Our Ref: BR/276/20/DOC

Town & Country Planning Act 1990 (as amended)
Town and Country Planning (Development Management Procedure) (England) Order 2015
Approval of details reserved by condition imposed under ref BR/32/16/PL relating to Condition No 3 -
new boundary treatments, 6 - pedestrian visibility spays and 7 - covered & secure cycle parking.
3 Glencathara Road Bognor Regis PO21 2SF

Arun District Council have decided to **APPROVE details reserved by this condition**

PROJECT NUMBER	3 GLE-18	DRAWING NO	A101 REVC
DATE	5th January 2021		
DRAWN BY	June Grinstead		
CHECKED BY		SCALE	1:100 / A3

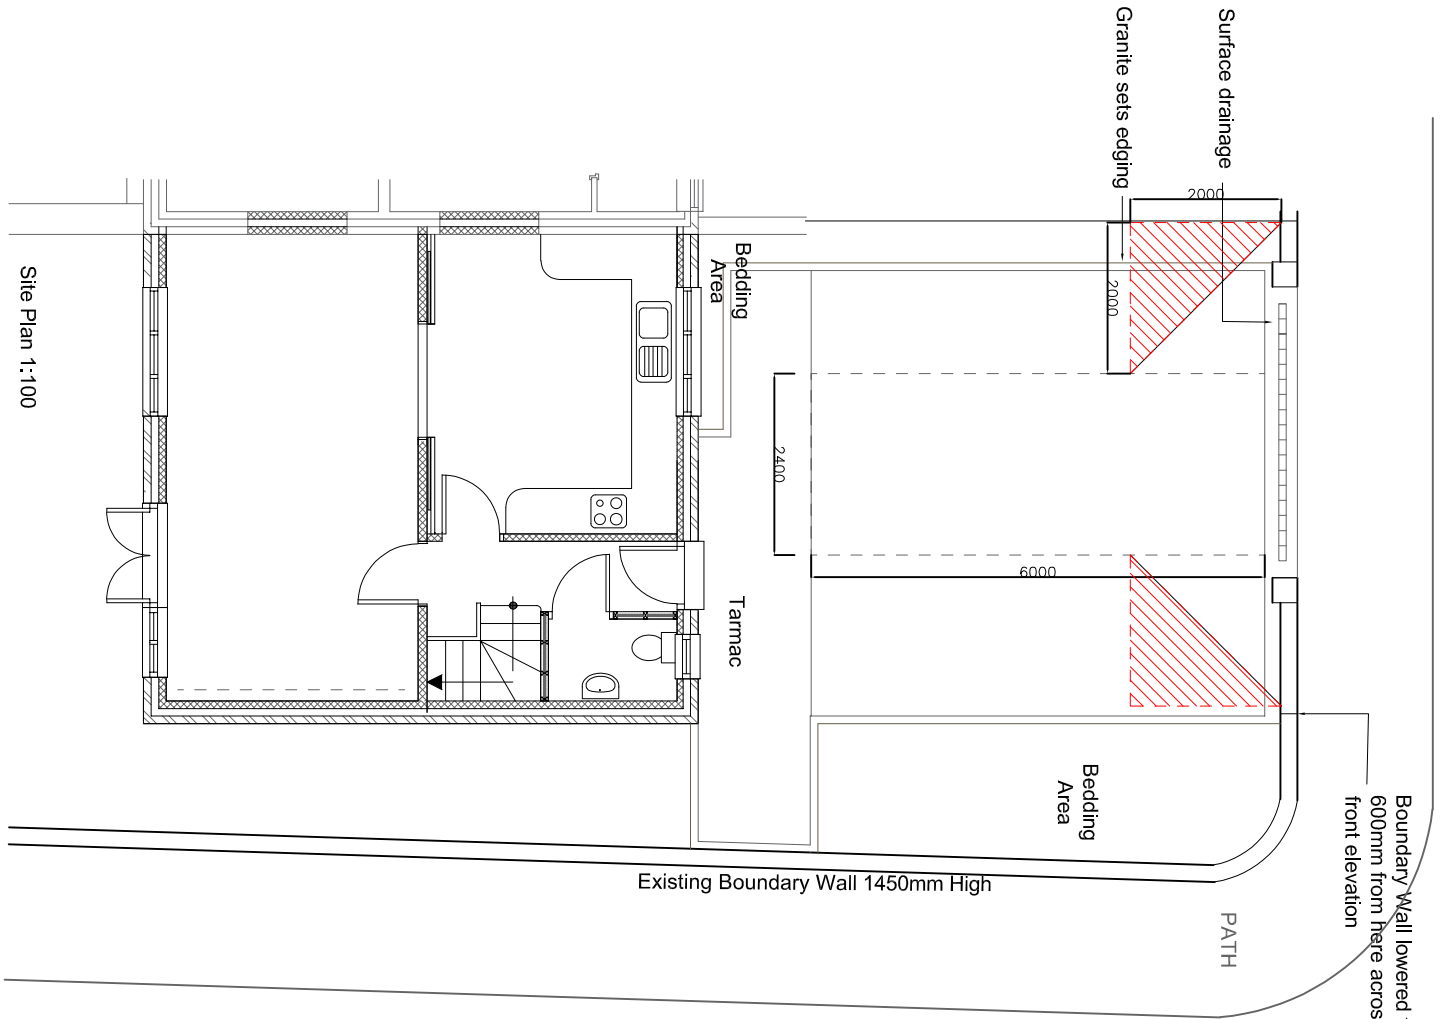
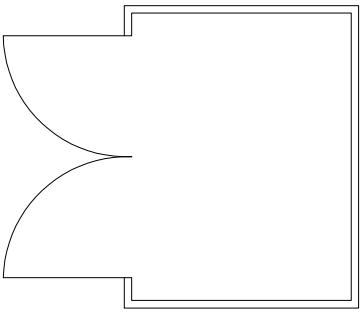
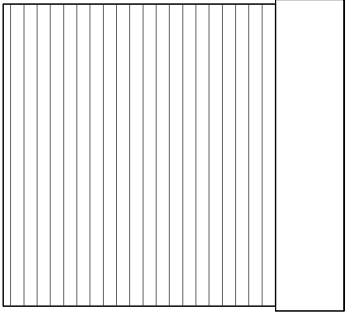
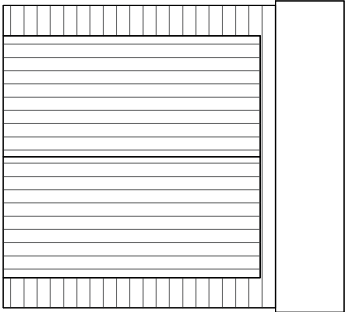
The applicant has provided details in accordance with WSCC and MfS guidance for covered and lockable cycle storage facilities and demonstrated its location along with elevations and floor plan on the submitted Dwg No A101 rev C. The LHA is satisfied that Condition 7 can be discharged.

The condition is therefore fully discharged insofar as the submission of site plan relates and on the understanding that the cycle storage shed will be permanently retained.
